### **The Northern Road Upgrade (SSI 7127)**

I refer to your notice of proposed development dated 16 June 2017 regarding the above state significant infrastructure proposal for upgrade of The Northern Road between Mersey Road and Glenmore Parkway.

Figure 25: Urban design strategy for vegetation and views showing broad urban design treatment zones

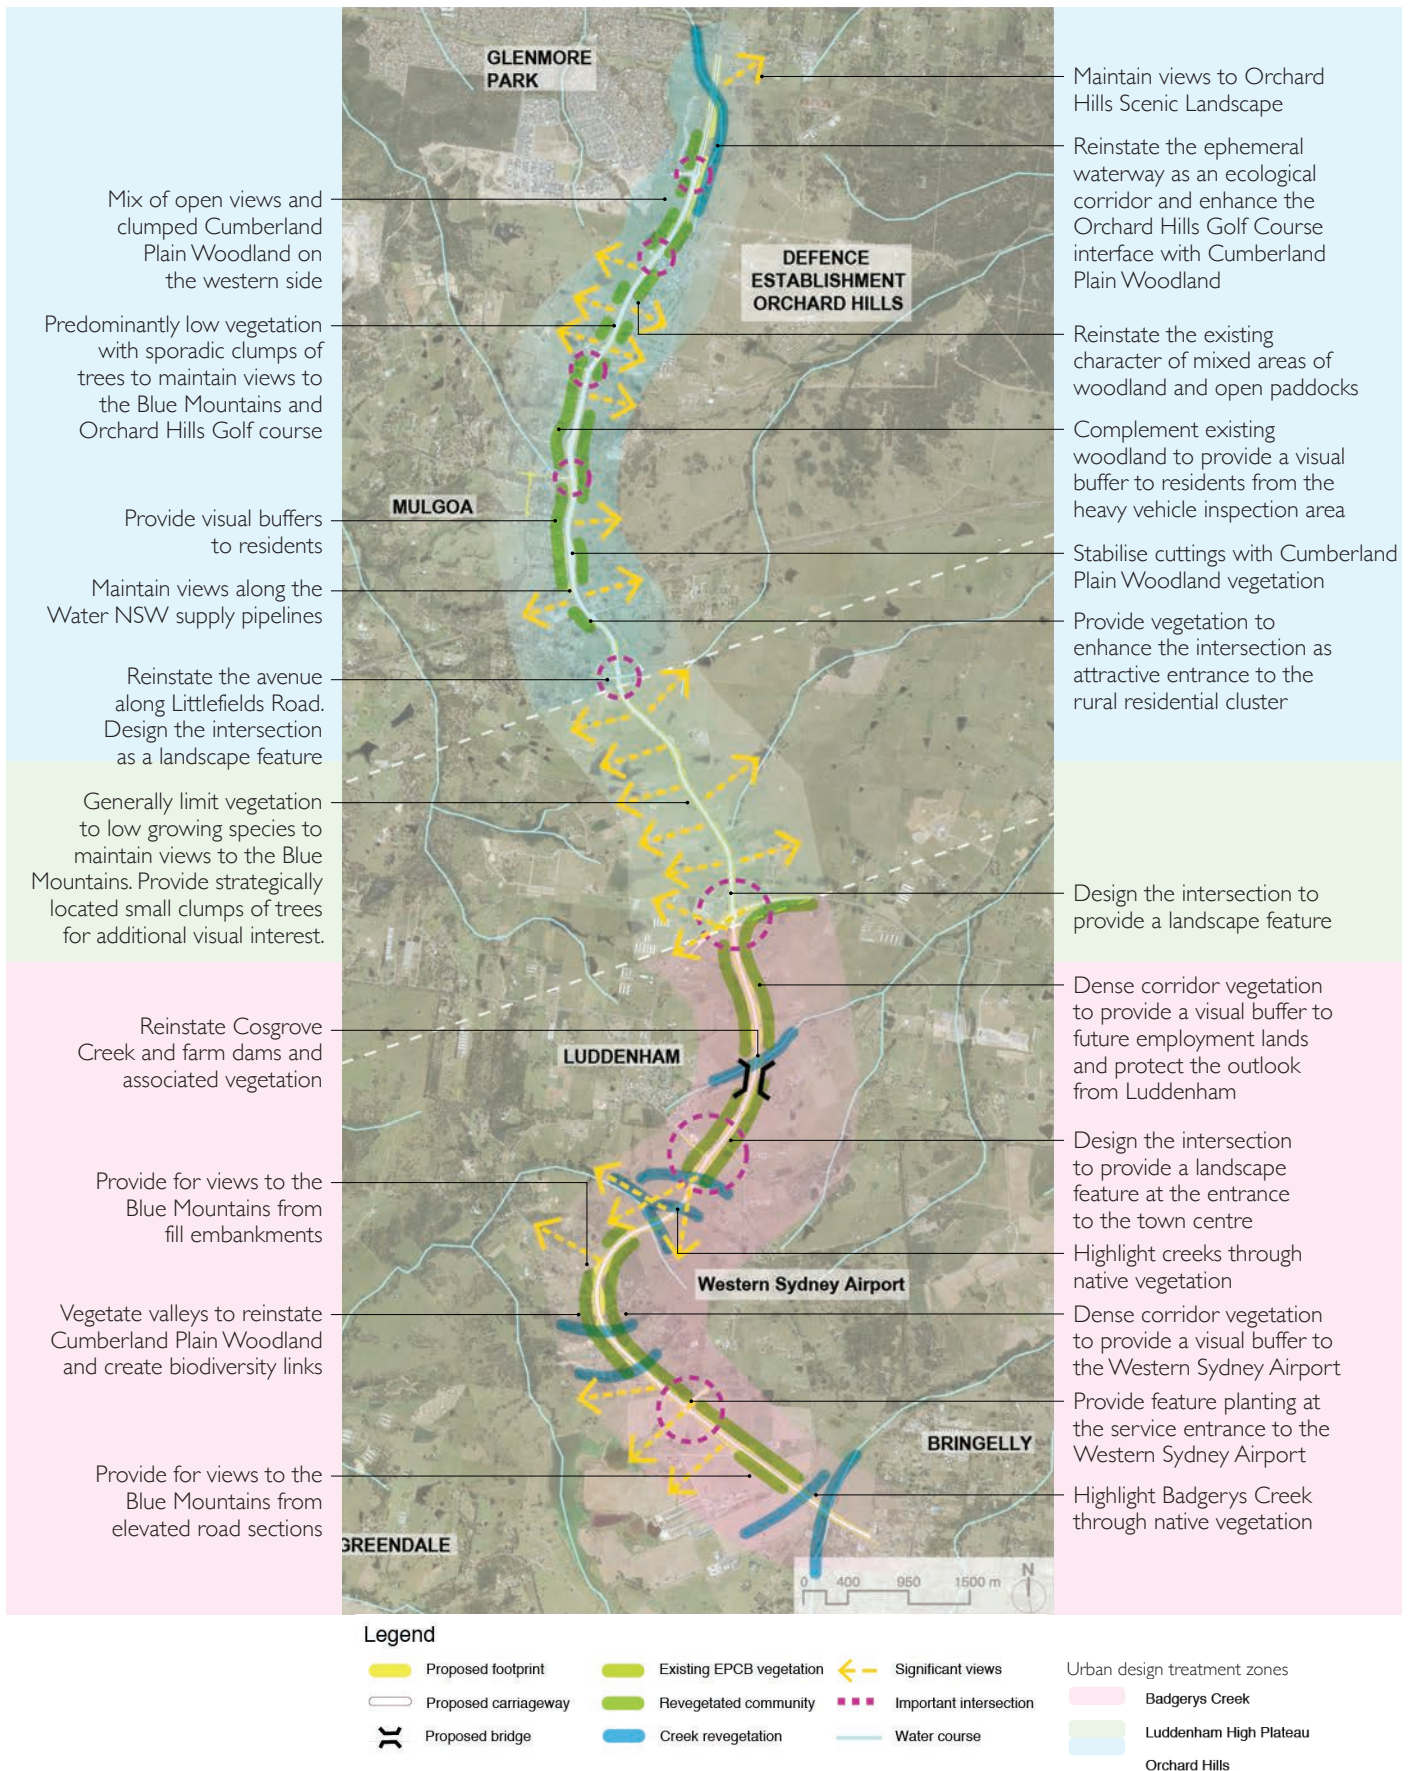
- Further clarification on how RMS contractors can safely, effectively and efficiently maintain medians
- Figure 25 of the Urban Design Strategy does not address the local government boundary between Penrith City and Liverpool. Further consideration should be given to the provision of signage and other potential landscape features to mark the boundary.

Sheet 10 - Chainage 9,175 to 10,400 approximately

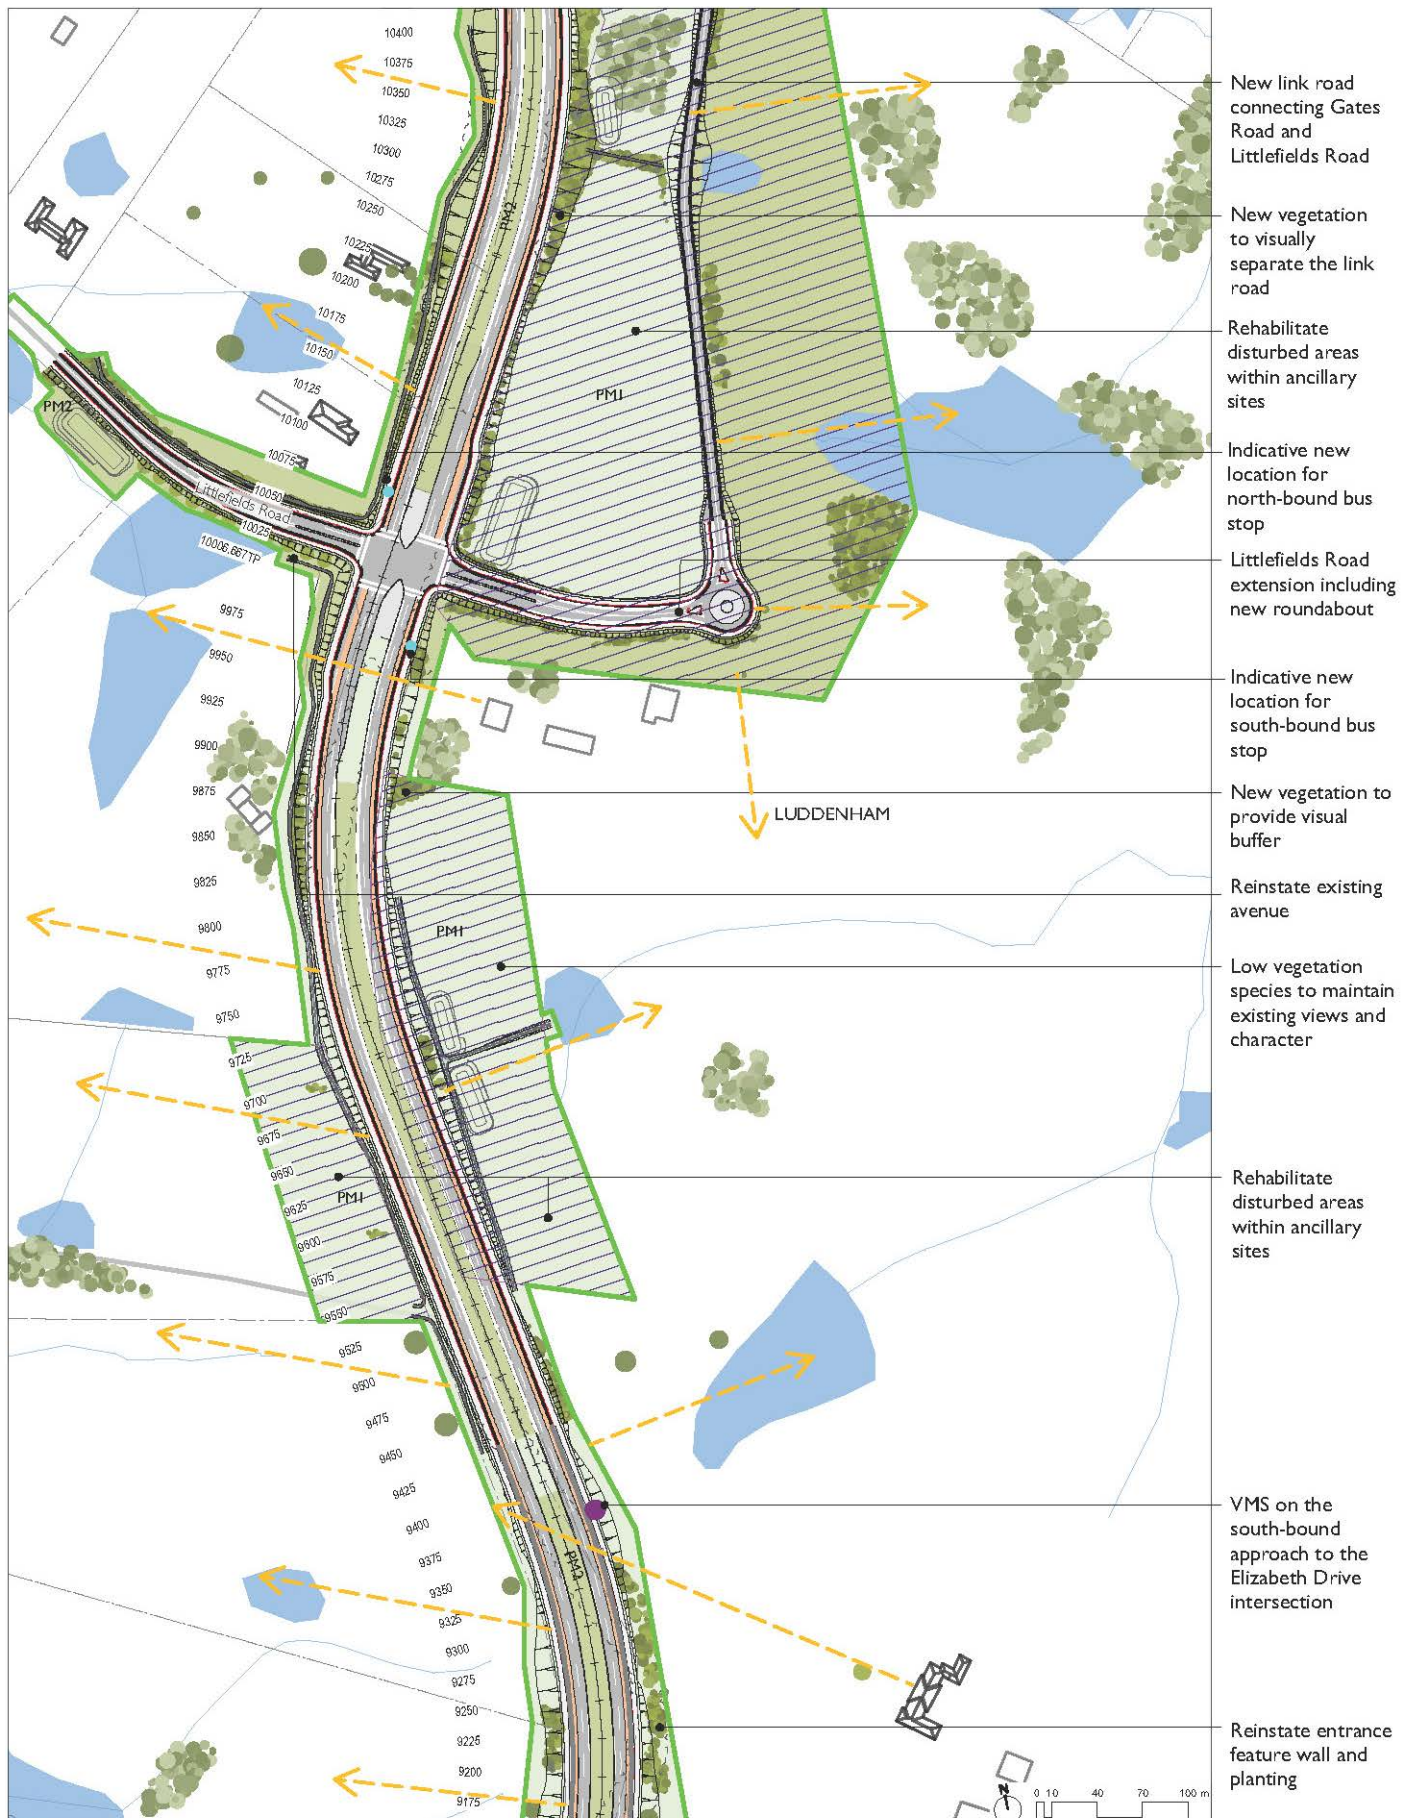
- Sheet 7 – The statement should address the change in local government areas through Council branded signage and other features
  - Sheet 10 – there is opportunity for PM2 ie. inclusion of planted trees between CH10050 and 10325 (east) and this should be further explored

Sheet 11 - Chainage 10,325 to 11,525 approximately

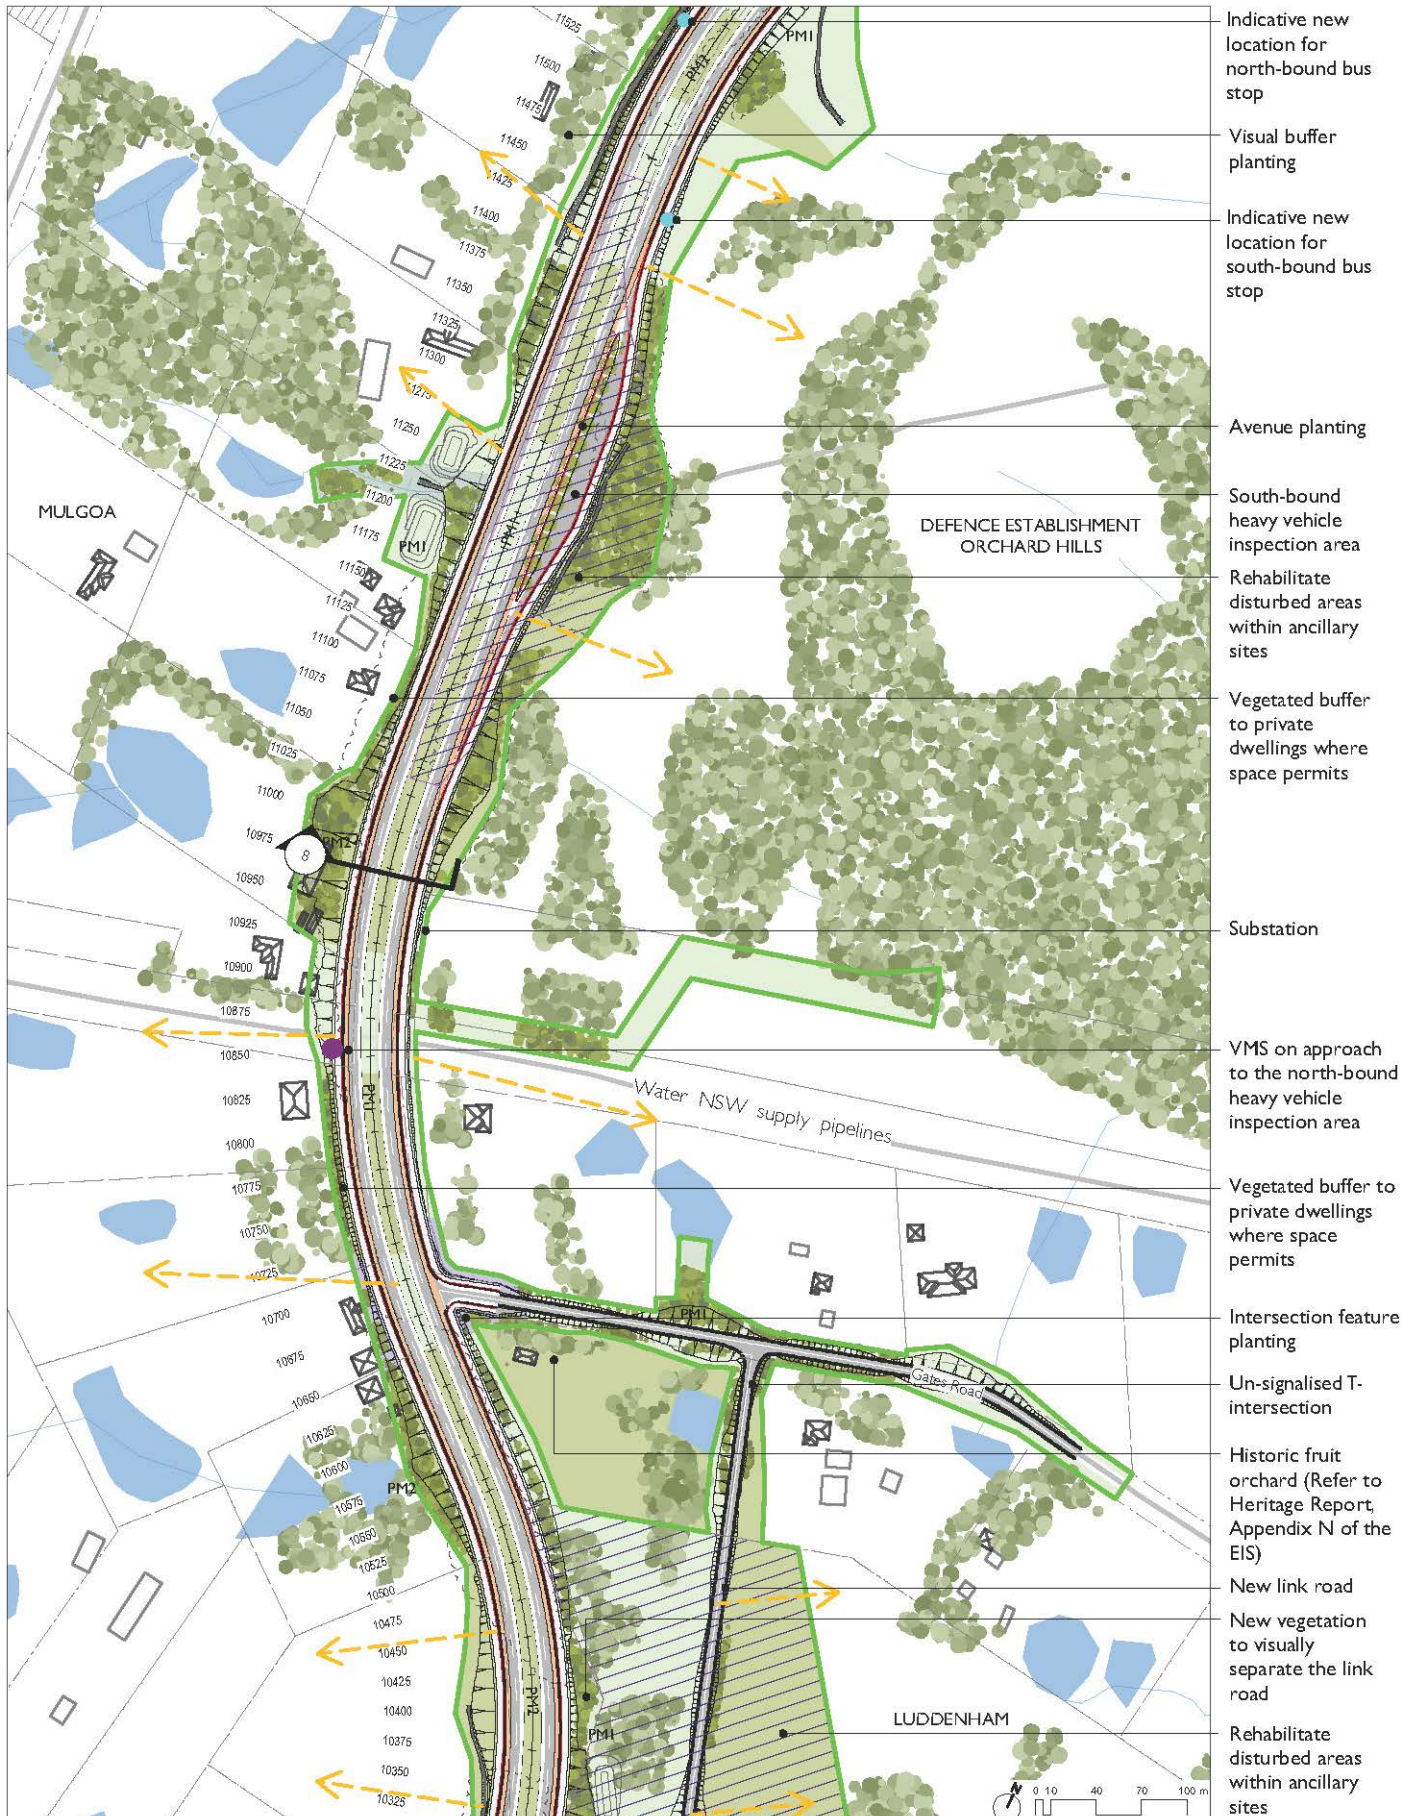
- Sheet 11 – the VMS at the pipeline is considered inappropriate given this is a feature in the landscape which has potential to be highlighted.

Sheet I3 - Chainage 12,700 to 13,875 approximately

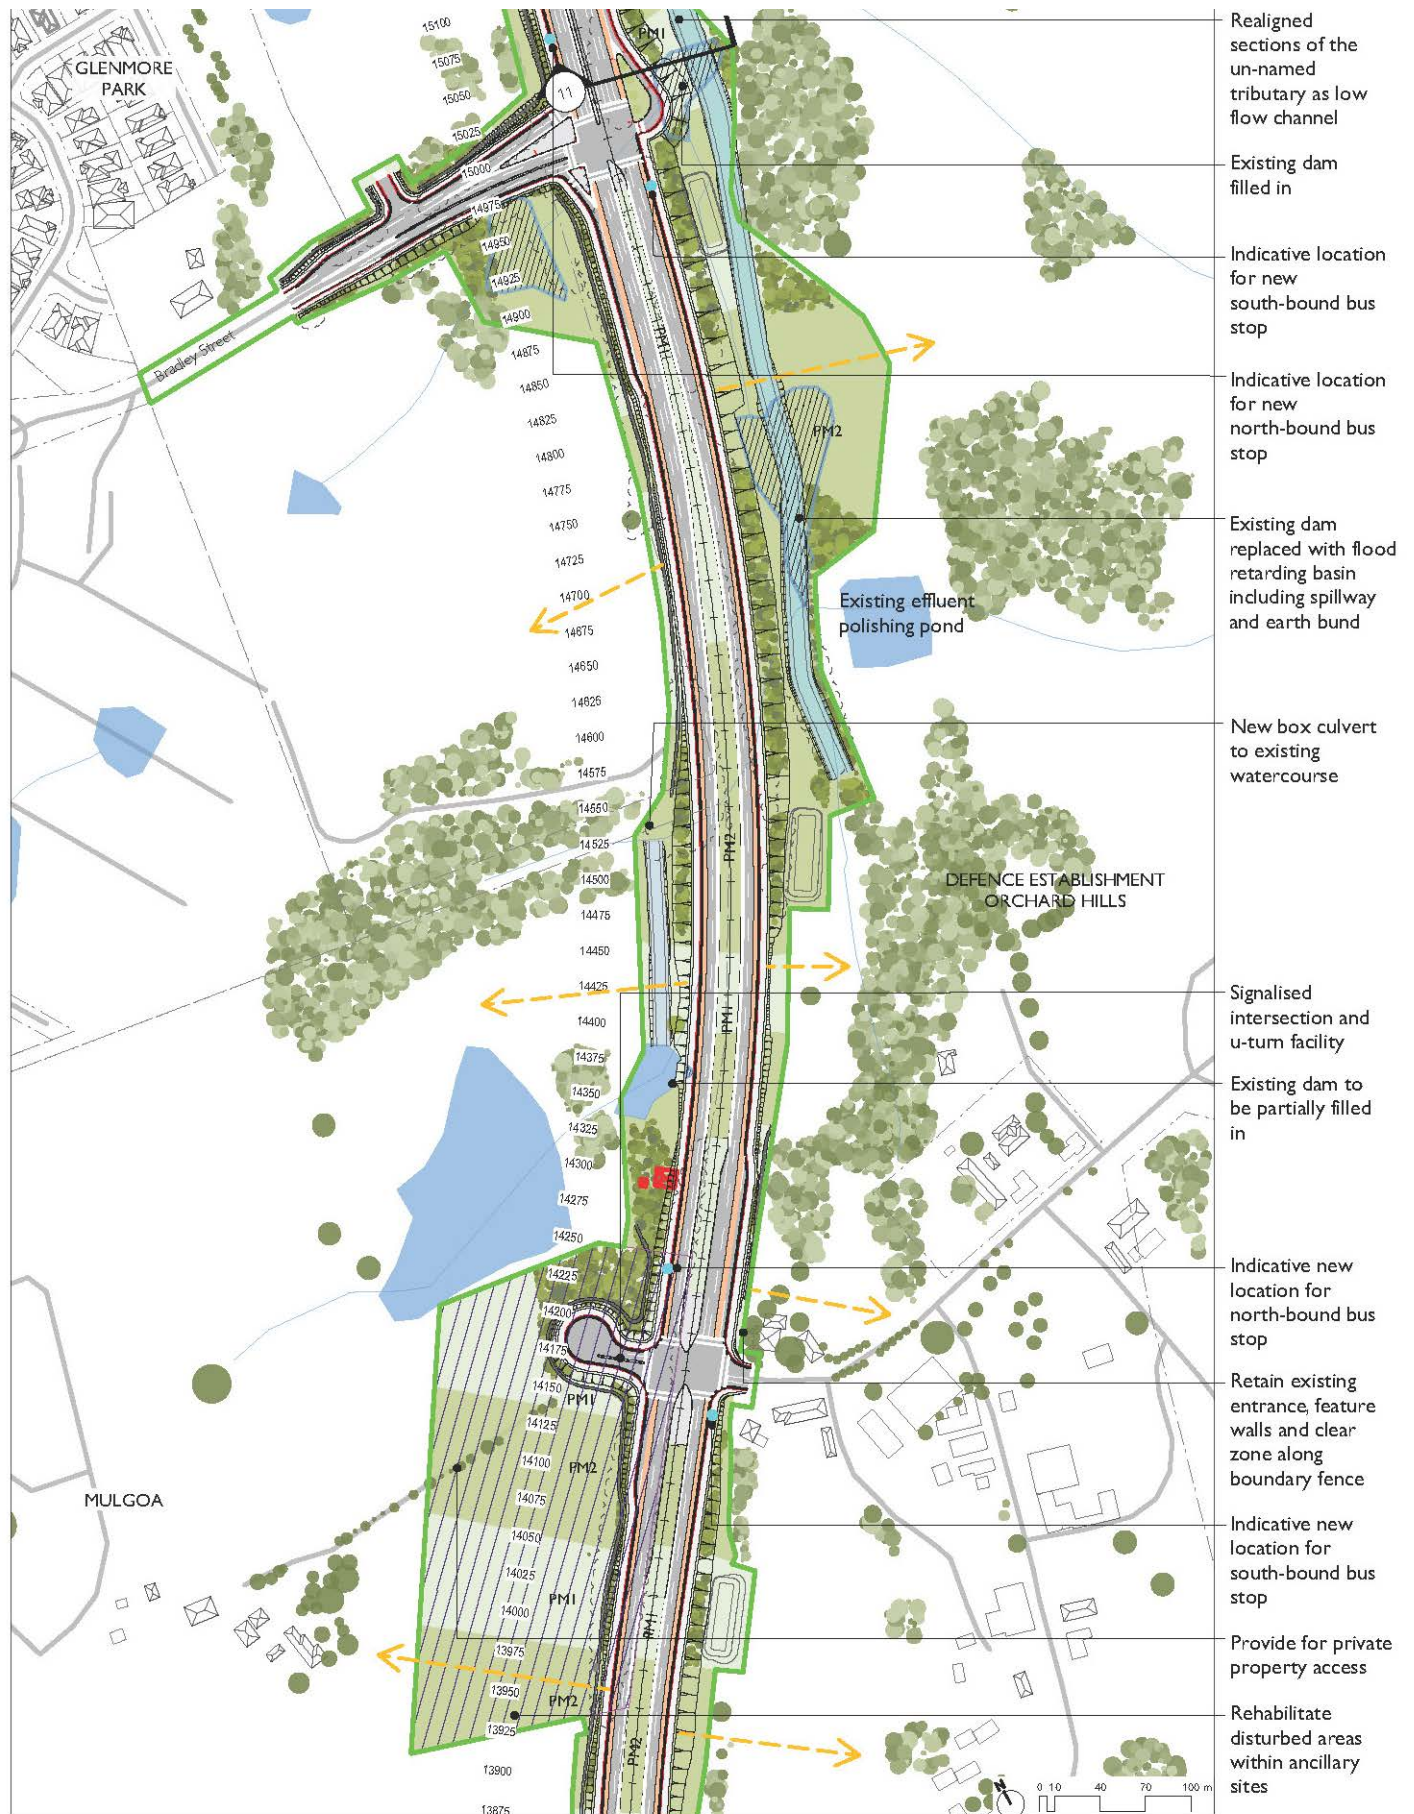
- Sheet 13 of the Urban Design Concept Plans (Page 87) indicates the planting of clumps of trees to balance screening with occasional views from the road corridor. The Mulgoa Valley has an established landscape and heritage character and replanting along the corridor should suitably respond to this character in terms of species type, groupings and plant locations.
